Re: **SSI-9487; Narromine to Narrabri (N2N) Inland Rail Project; PIR Submission**

21 September 2022

APPENDIX A: Issues identified in the PIR

The Australian Government is delivering Inland Rail through the Australian Rail Track Corporation (ARTC), in partnership with the private sector.

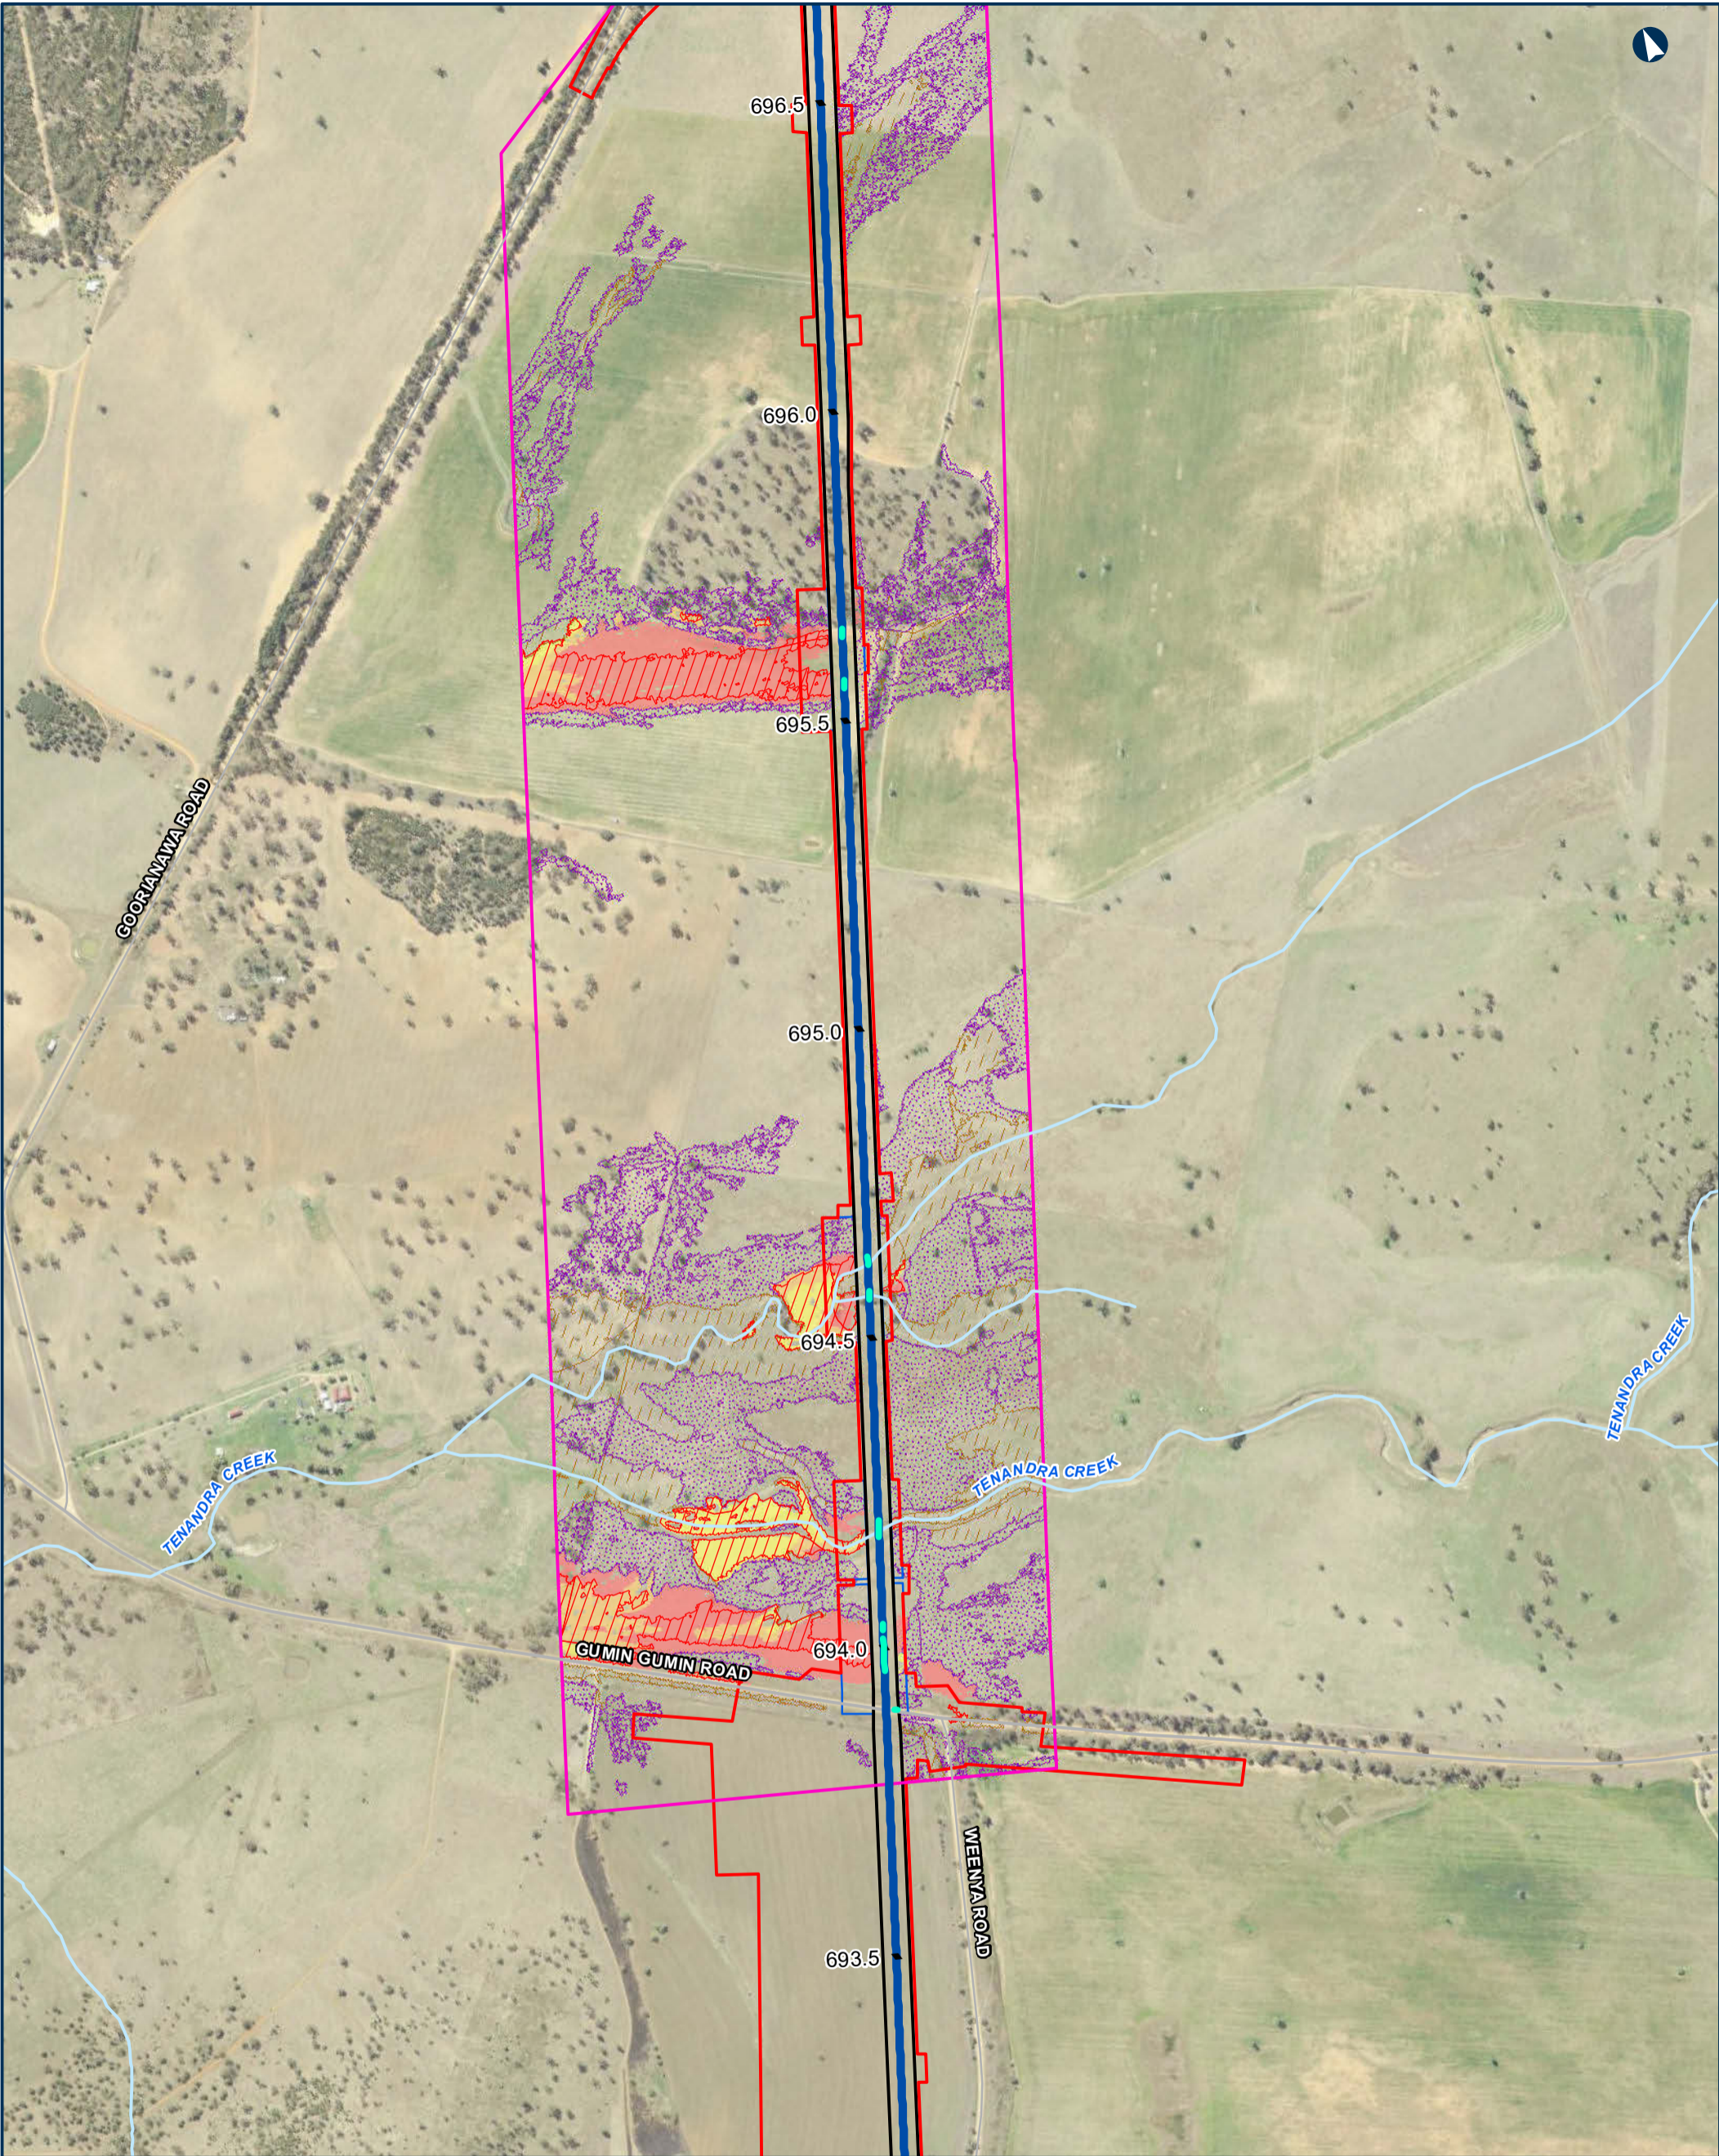
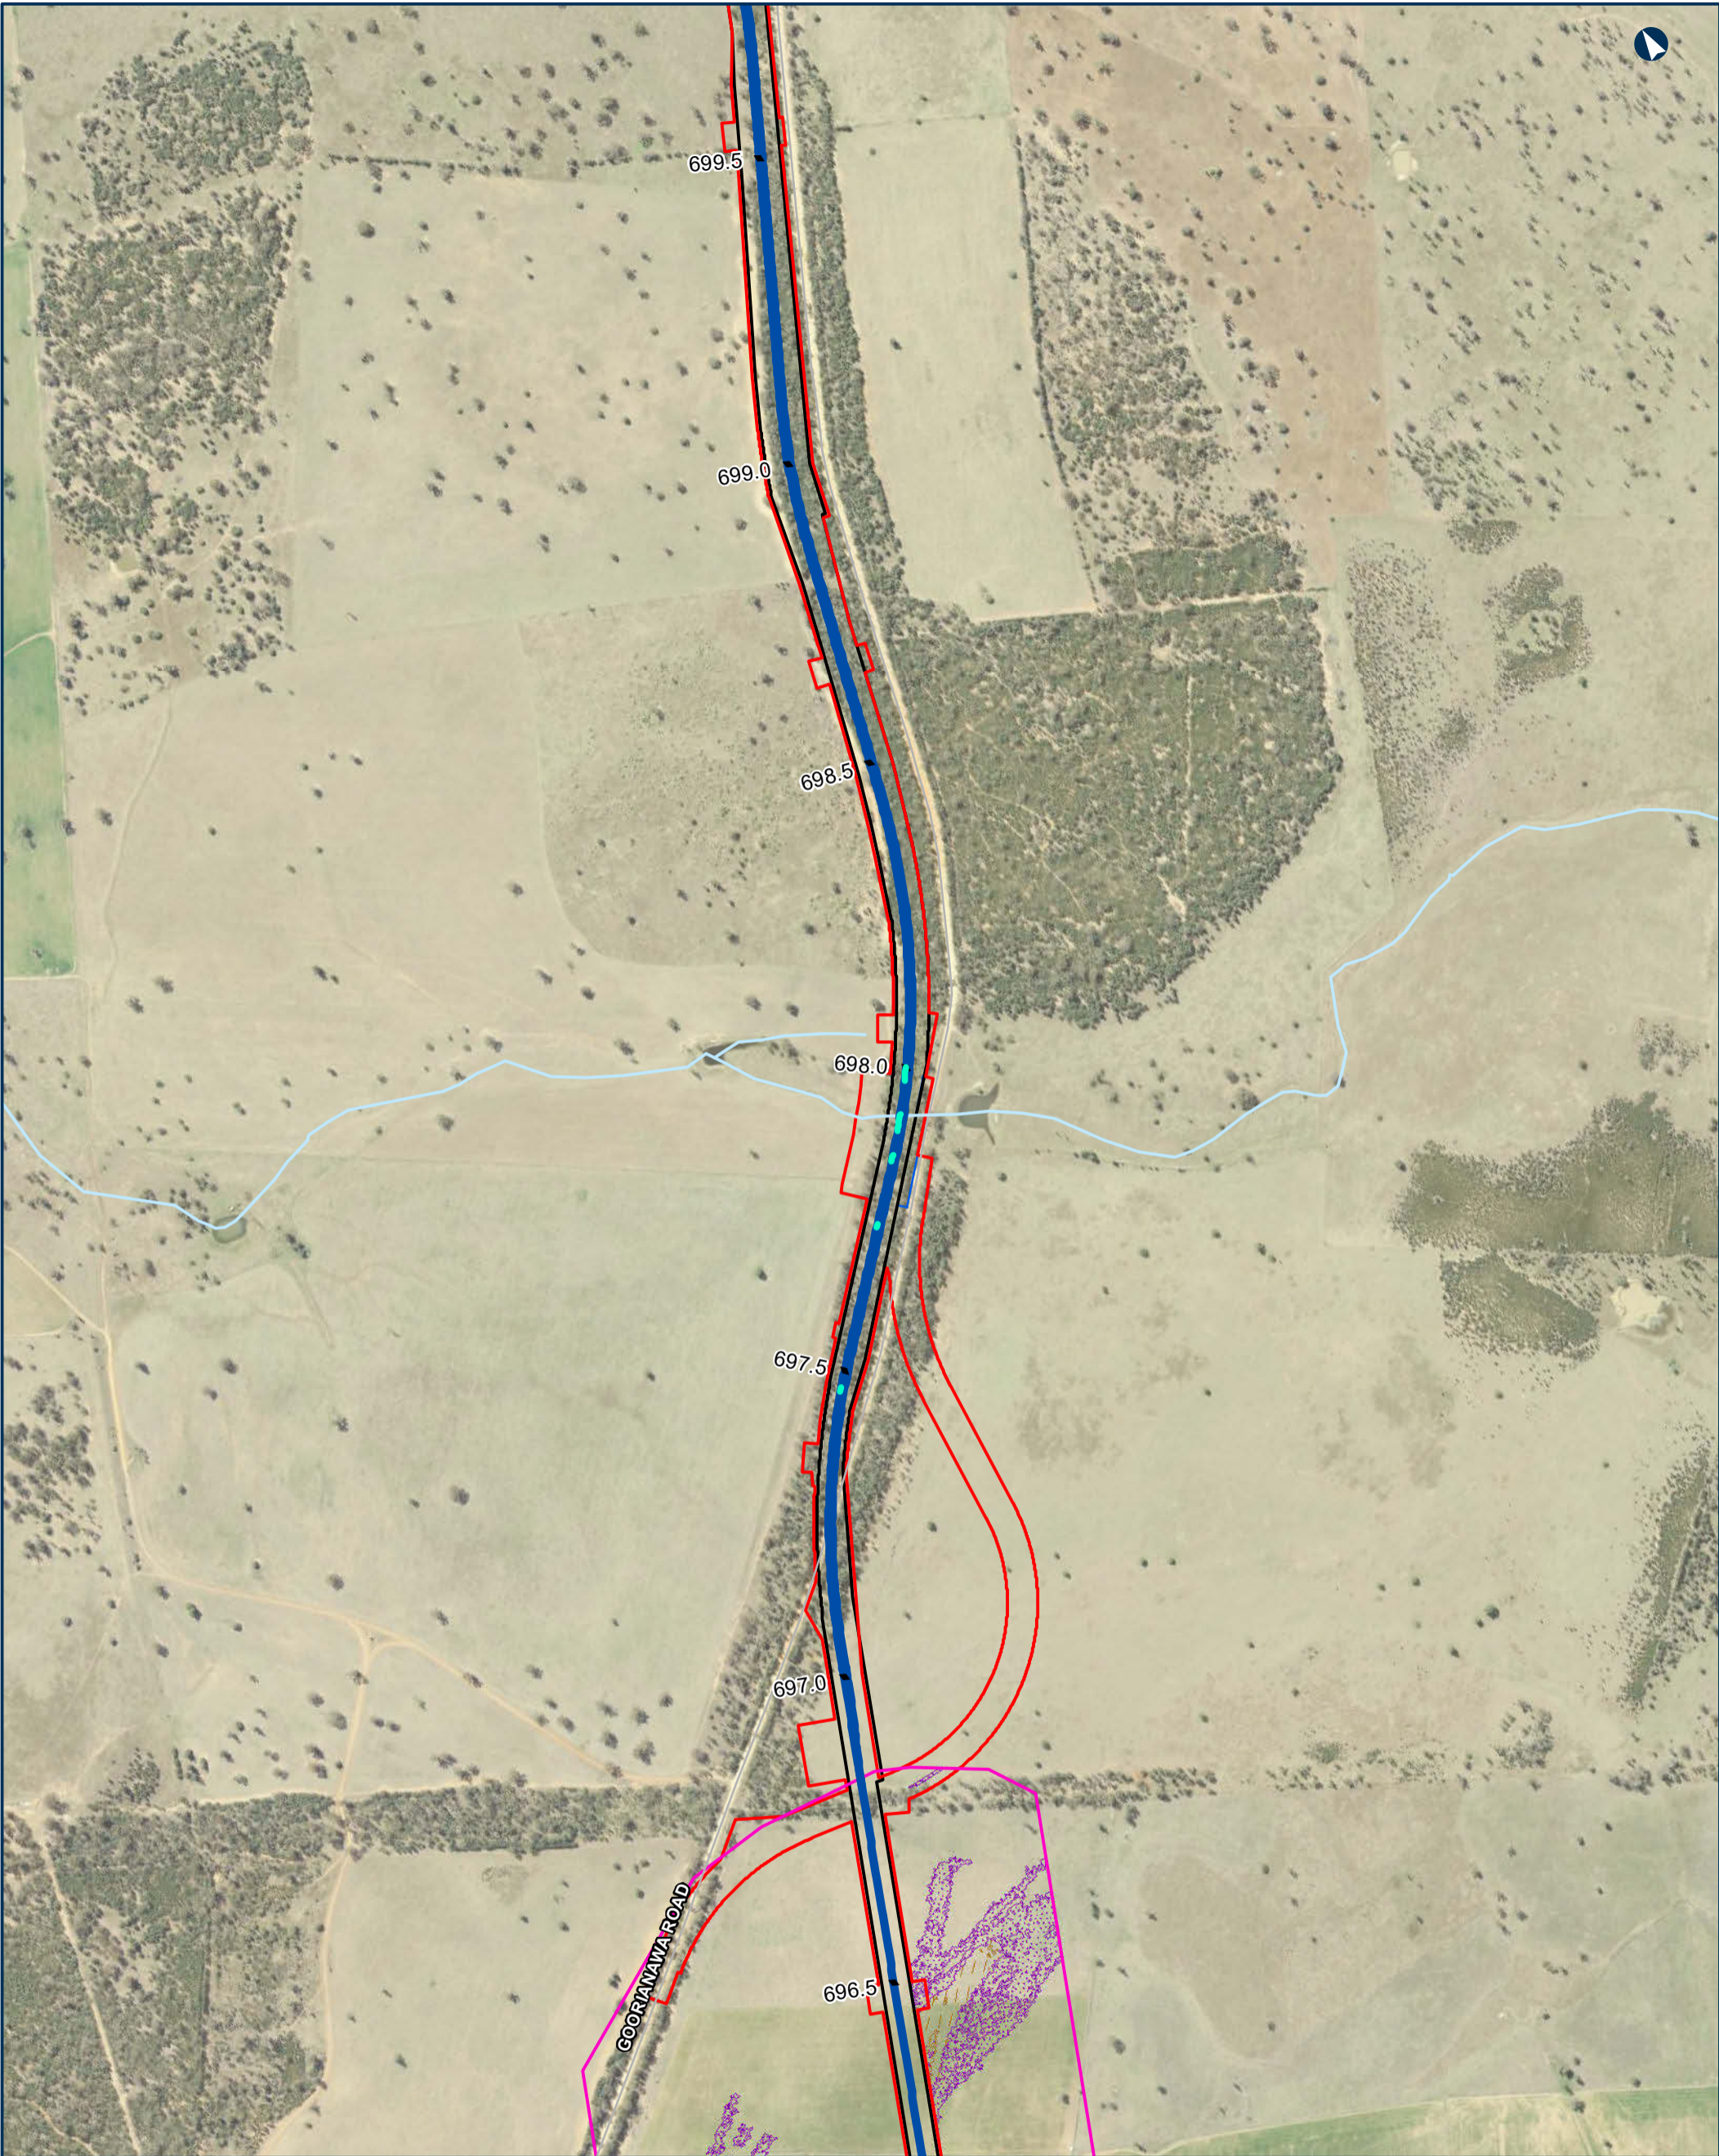
Transport does not accept any new inundation of the State Road Network including the pavement and unsealed or unprotected road edges. Both the EIS and PIR indicate that highways and roads will experience adverse flooding impacts because of the proposed Inland Rail project. ARTC has assumed Quantitative Design Limits (QDLs) based on the adjoining N2NS project. On that project breaches to the QDLs are now requiring extensive mitigation. QDL concessions granted on N2NS where highway upgrades are planned are not applicable to the N2N project. As such, TfNSW objects to the proposal as submitted. TfNSW is willing to reconsider its objection, provided suitable QDLs can be agreed upon that do not introduce new flooding to State assets.
